Re: 1 Joy Place

Jean Fraser <jf@portlandmaine.gov>

Wed, Aug 30, 2017 at 5:46 PM

BRICK SIDEWALK SECTION

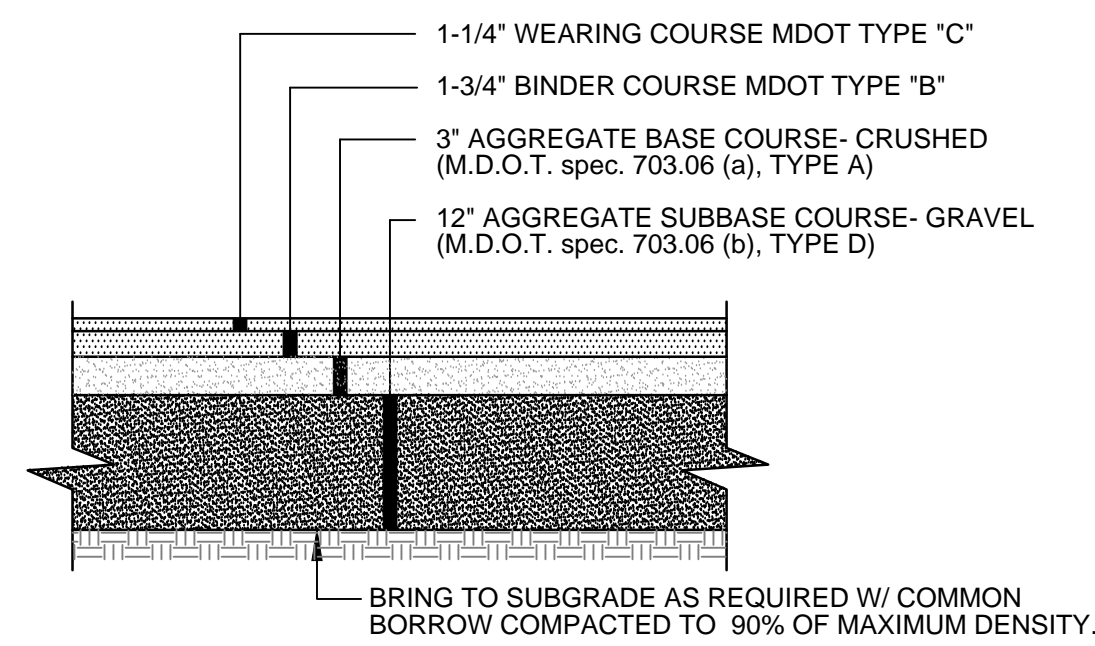
The brick walkway is OK as is the bollard lighting in principle (although HP will need to review the detail for the bollards and we need to see details of the walkway regarding slope/crossfall) but the walkway has to have 4 feet of clear brick (with no planters or trees in that 4 feet at any location) to meet ADA requirements - and the proposed street trees eat up most of that 4 feet.

LANDSCAPE PLAN
L.1
REV. 9.13.17 PAX 1.10.18
REV. 8.7.17
REV. 8.26.17

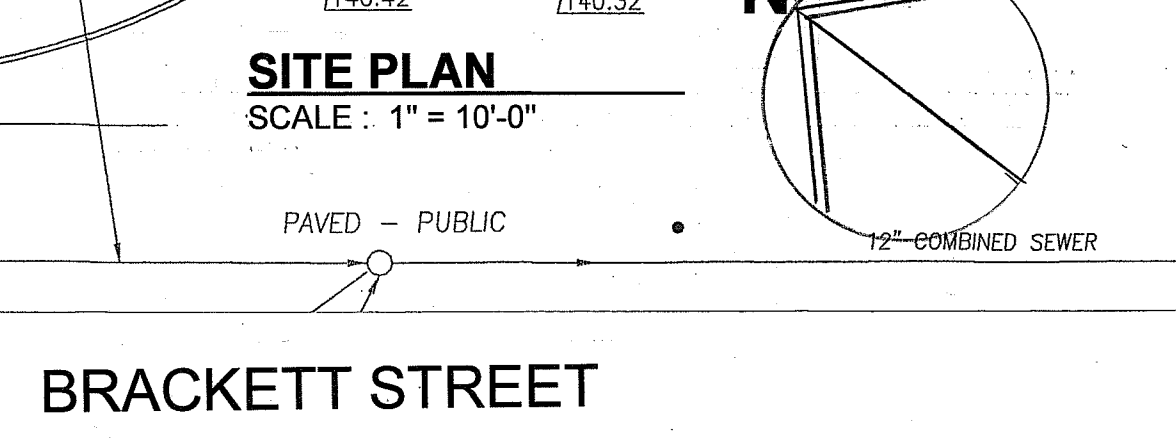
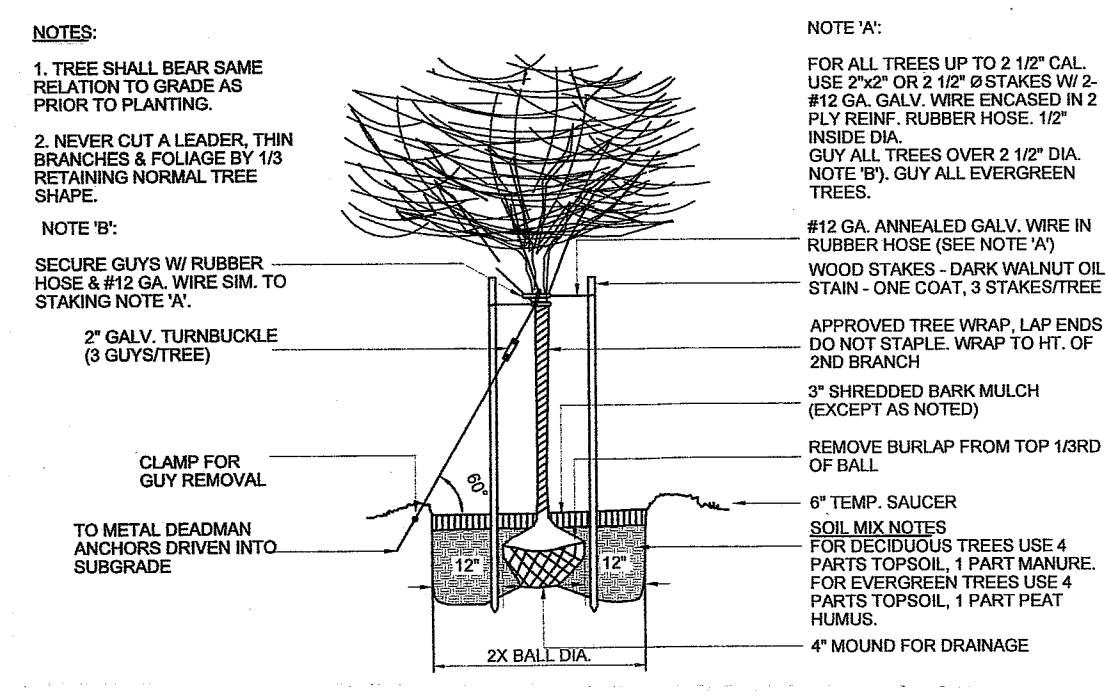
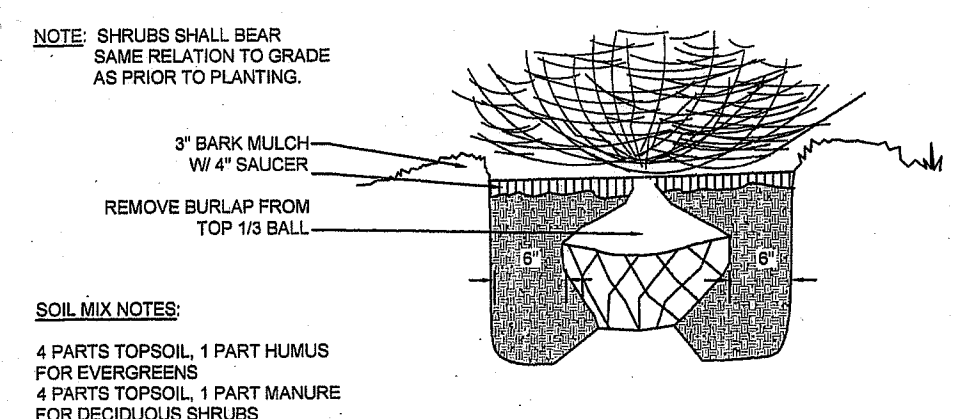
Reviewers asked me to get further information about the boundary conditions with the parking lot before we form a final view regarding the inclusion of the three street trees along Joy Place.

We are not sure that these trees are needed since it appears there are some trees along here already.

There are some concerns regarding the introduction of the street trees - whether they would inhibit snow plowing of the pedestrian walkway in the winter, and whether they would survive with a flush planter surround.

Deb Andrews (HP) would prefer a simpler, more low key planter design if planters/trees are included.

As I mentioned in my e-mail to Todd below, there needs to be some form of boundary treatment along the property boundary to the south - the wood fence stops at the tandem parking area and maybe that should be continued (at a lower height) along the property boundary to Brackett Street (this would probably be instead of trees and to buffer the jersey barriers.) Another option would be low planting if there is room (or a combination)

So the trees and planters need to be reconsidered taking account of the points raised above including how they integrate with the existing trees. I suggest you revise the Landscape Plan and send it along with the requested info asap.
